Introduction – Appendix 4

Table of Environmental Impact Assessment Scoping responses from West Oxfordshire and Cherwell District Councils	
District Council Response	How/where it is addressed in the Environmental Statement (ES) or elsewhere
Part 1 West Oxfordshire District Council (WODC) comments	
<p>1. The community and social impact of development will be a critical factor. Those services where reliance is placed upon Woodstock as a service centre will need to acknowledge the capacity of existing facilities & problems with congestion & parking in the central area, & the potential impact on the tourist economy of visitors being unable to easily access parking spaces.</p>	<p>The range and location of existing services and facilities that will be used is addressed through the Social and Community chapter of the ES. The Transport Assessment (TA) explains that the link and ride will provide long term parking for visitors, and the new retail unit proposed will provide a local food shop for residents to avoid/reduce food shopping trips.</p>

JOB TITLE		Woodstock East		CLIENT		Pye Homes Vanbrugh Trust	
DRAWING TITLE							
Proposed A44 site access							
SCALE	DRAWN BY	DATE	DRAWING No	REVISION			
1:1000@A3	BP	Sept14	15291-22	B

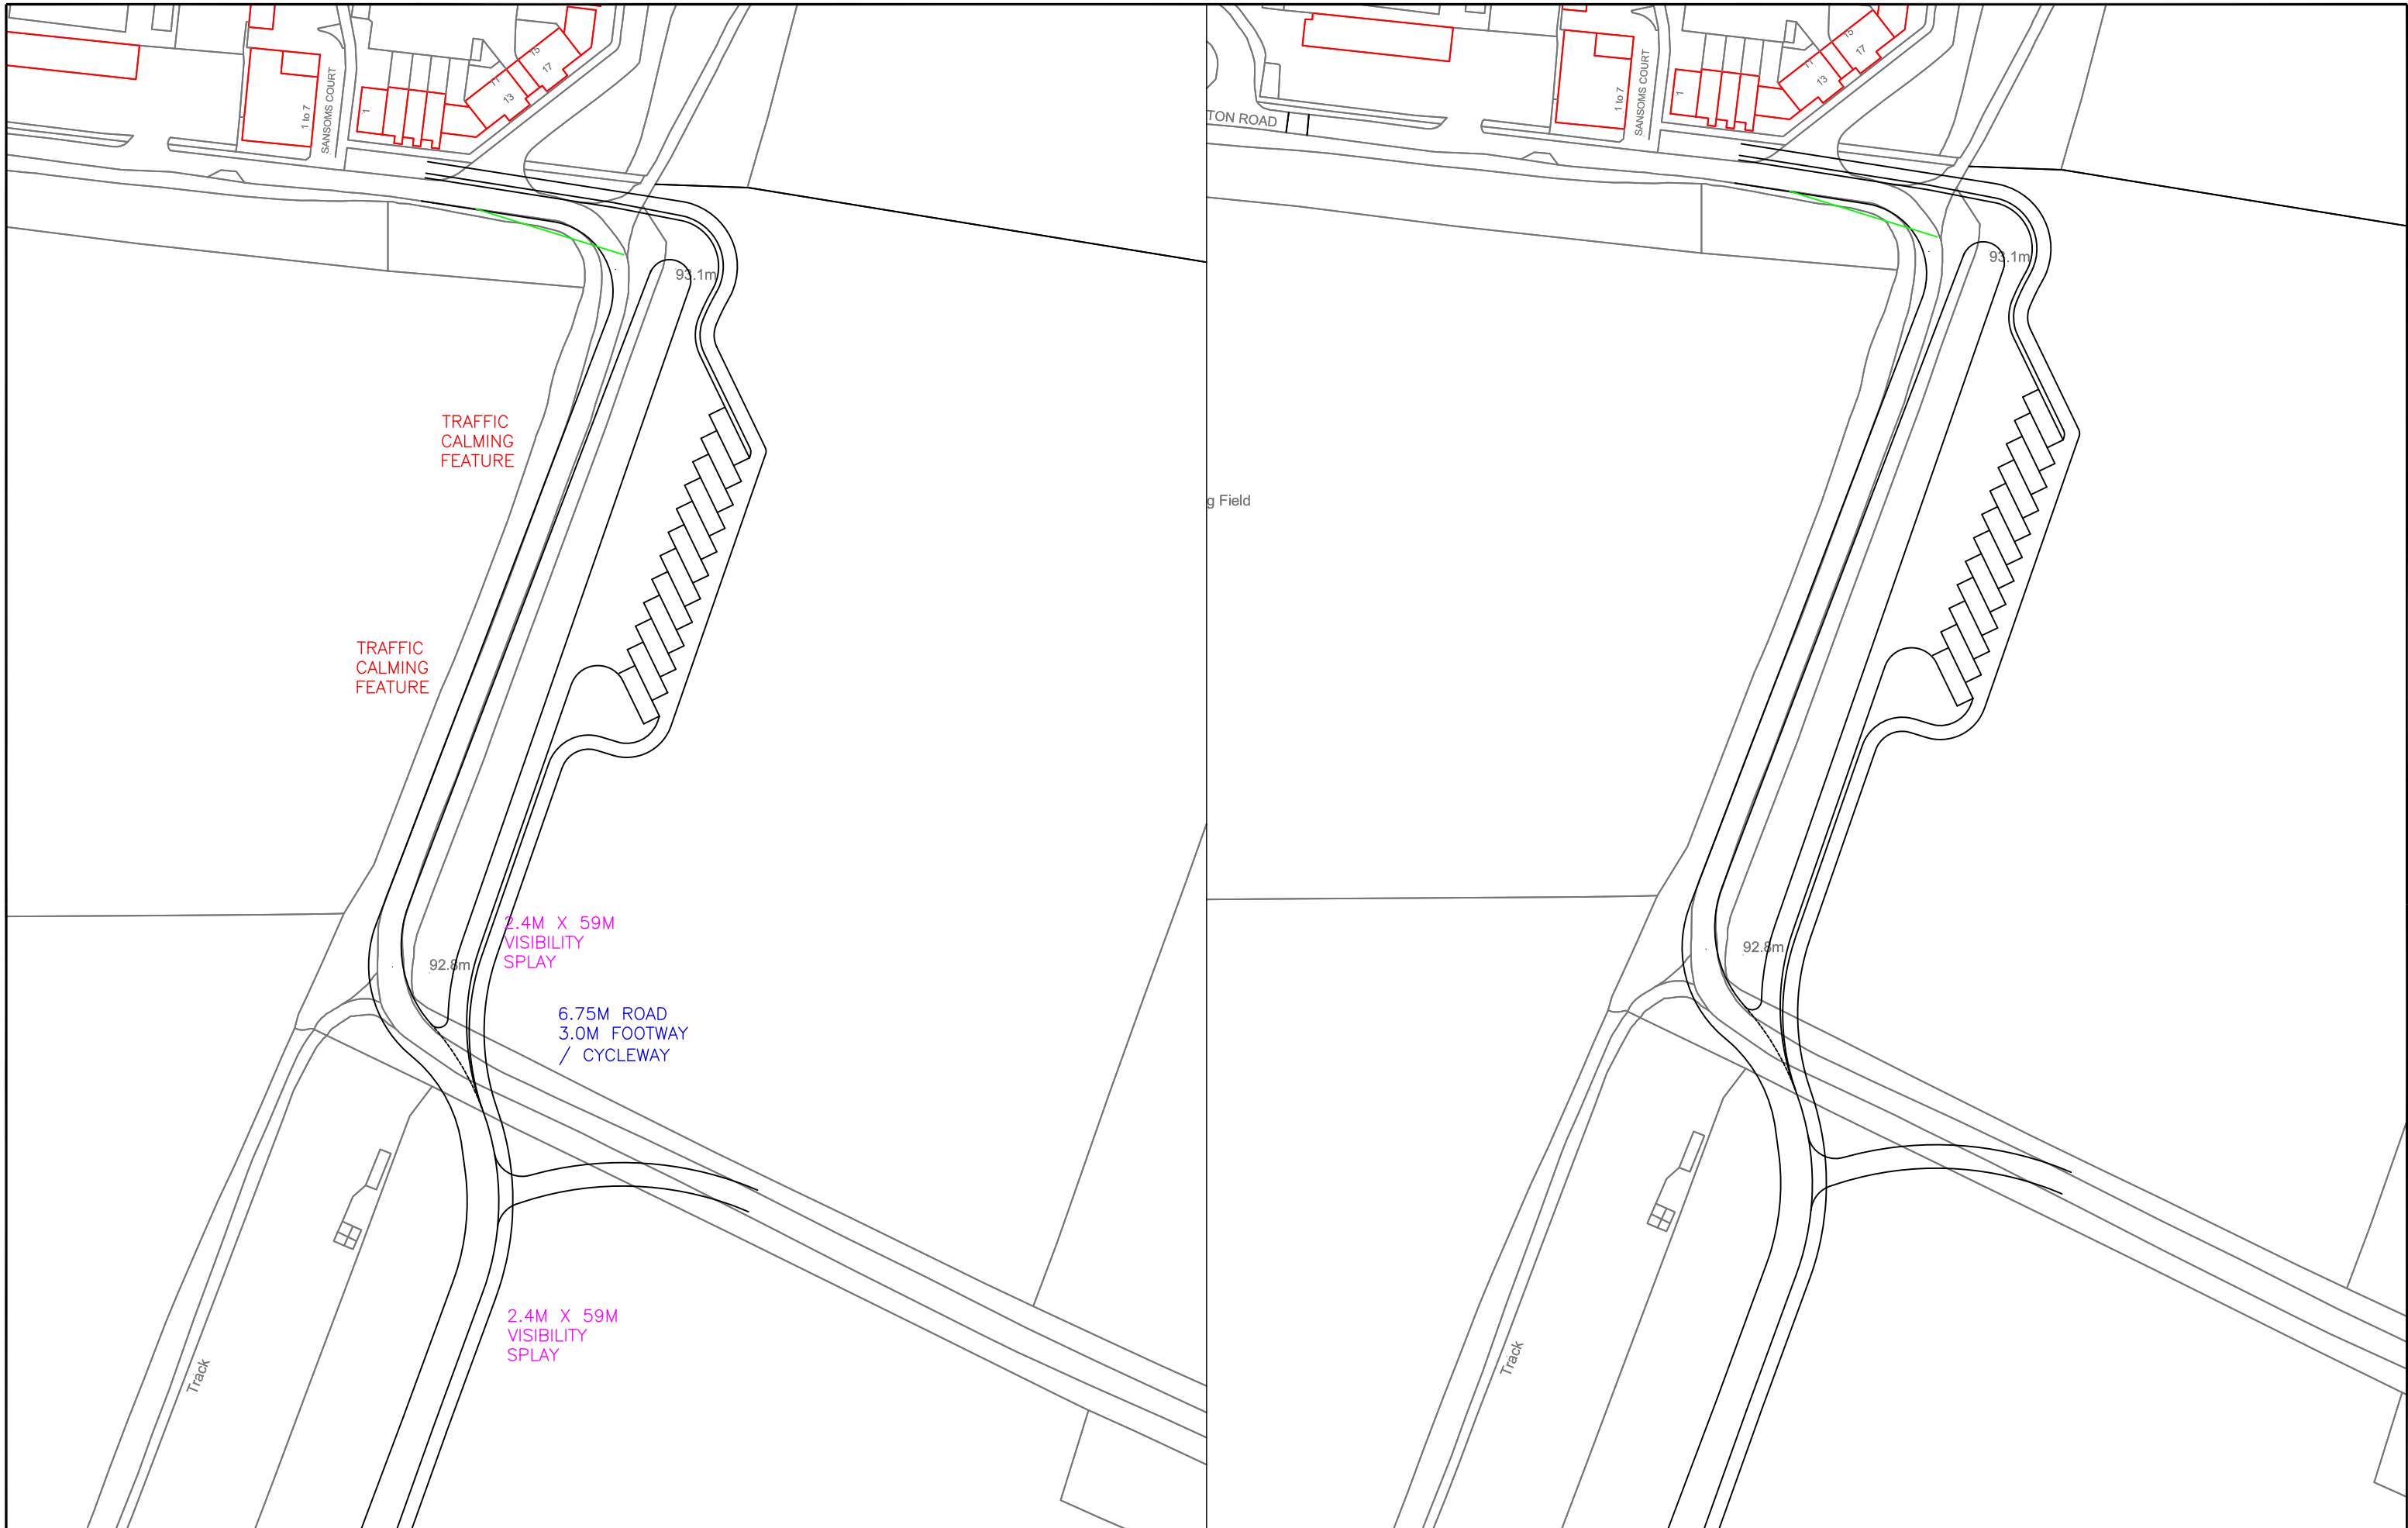
<p>9. Construction Traffic Management Plan will be needed. WODC provide guidance on content</p>	<p>A construction management plan has been provided with the TA</p>
<p>10. Scaled Drawings</p> <ul style="list-style-type: none"> • Drawings required showing proposed access arrangements for site, to include vision splays, road width, junction radii etc (to include Safety Audits on proposed access arrangements & subsequent highway mitigation requirements); • Parking arrangements, turning & servicing areas; • Racking plans for refuse & HGV deliveries • Internal road, footway & cycle links (to accord with MfS & constructed to OCC specifications) • S38 Adoption area drawings 	<p>A full complement of plans is provided as part of the planning application. The level of detail is proportionate to the scale of the development and to the fact that the bulk of the development proposal is submitted as an outline planning application at this stage.</p> <p>A number of the detailed elements of the scheme will be submitted as reserved matters as is usual for a development of this scale; more detailed plans will then be provided.</p>
